**KIRKLEES METROPOLITAN COUNCIL
INVESTMENT & REGENERATION SERVICE**

**DELEGATED DECISION TO DETERMINE PLANNING APPLICATIONS TO
CARRY OUT DEVELOPMENT WITHOUT COMPLIANCE WITH PLANNING
CONDITIONS PREVIOUSLY ATTACHED**

Reference No:	2025/70/93149/W
Site Address:	16, Harvey Royd, Almondbury, Huddersfield, HD5 8SP
Description:	Variation of condition 2 (plans) on previous permission 2024/92589 for erection of single and two storey side and rear extensions, with erection of dormers
Recommending Officer:	Laura Yeadon

**PROPOSED ROOF PLAN**  
SCALE 1:100 @ A1

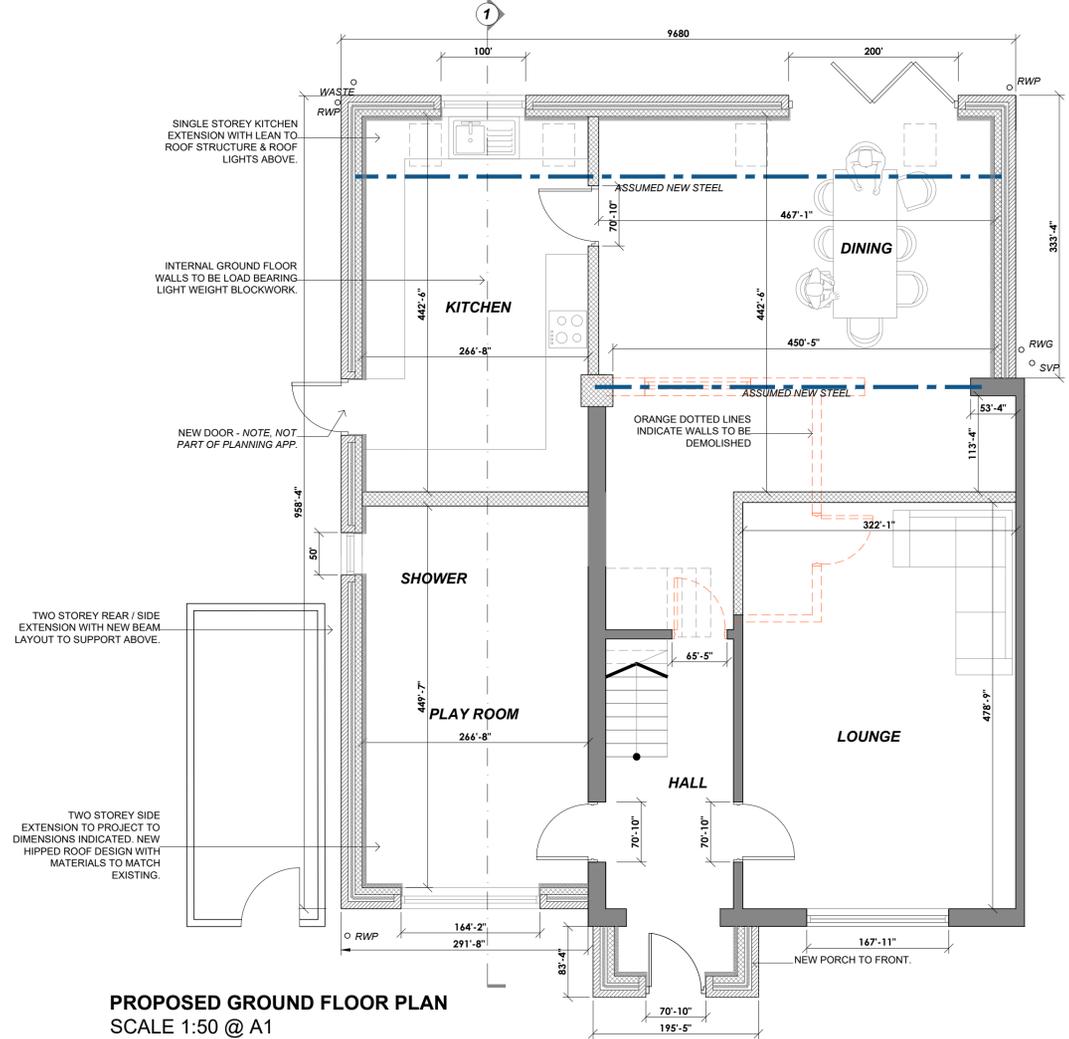
The application seeks to enlarge the dormer extensions within the roof space. The dormers would be retained as 2 no. separate identical features. The differences are as follows:

Width – 3.3 metres
Height – 2.3 metres
Projection – 4.2 metres

The principle of dormer extensions were established under the previous application. It is proposed that the dormer extensions would be increased in size as part of this application. Whilst the roof of the proposed dormers would be shallow pitched due to the increase in width, they would be retained as pitched roof dormers rather than flat roofed dormers which would be considered out of keeping with the resultant dwelling, once extended.

- Relate to the appearance of the house, roof and similar to those already approved;
- Would be constructed from composite cladding which is a typical finishing material for such structures, The finishing colour of the dormers can be secured by an appropriately worded condition
- Would not dominate the roof space by ensuring that the roof form can be clearly read and would not project above the ridge of the roof of the house

5. The rear dormer walls and face shall be a dark grey colour finish or be tiles / slates which, in all respects, match those used in the construction of the existing building. The materials of construction and colour finish approved by this condition shall be thereafter retained.

**PROPOSED SIDE ELEVATION**  
SCALE 1:100 @ A1

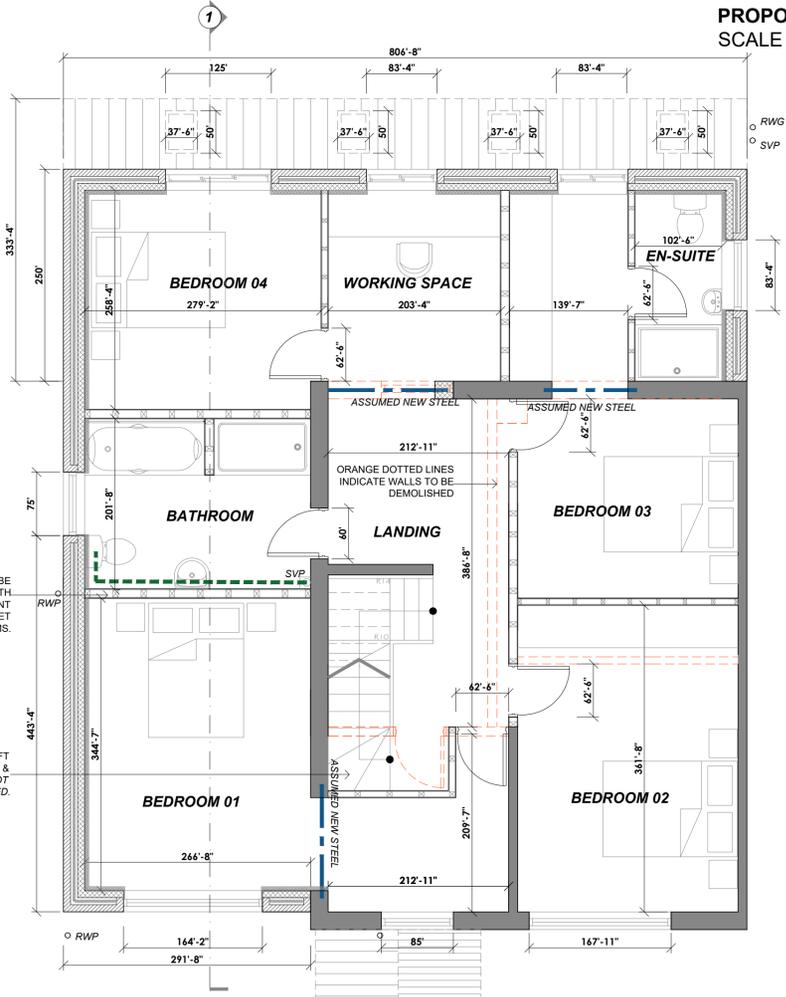
- If these works are to proceed then the height of the side elevation wall should be no higher than the height of the eaves of the existing building

- In addition, the roof should be hipped to match the existing hip on the existing dwelling

Response: The height of the side elevation wall has been assessed and deemed acceptable as part of the previous scheme which is incorporated into the scheme the subject of this application.

Response: The alteration from a hip to gable roof form was considered acceptable as part of the previous scheme.

**PROPOSED REAR ELEVATION**  
SCALE 1:100 @ A1

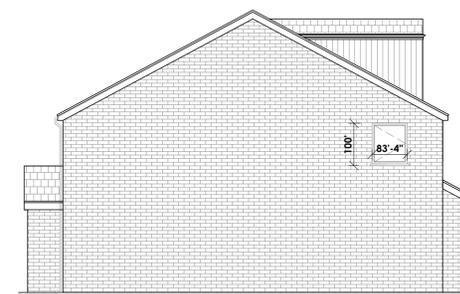
In terms of overlooking, as the dormers would be set back from the gutter line where windows within the rear elevation of the extension have already been approved, it is not considered that there would be a significant increase in harm from overlooking.
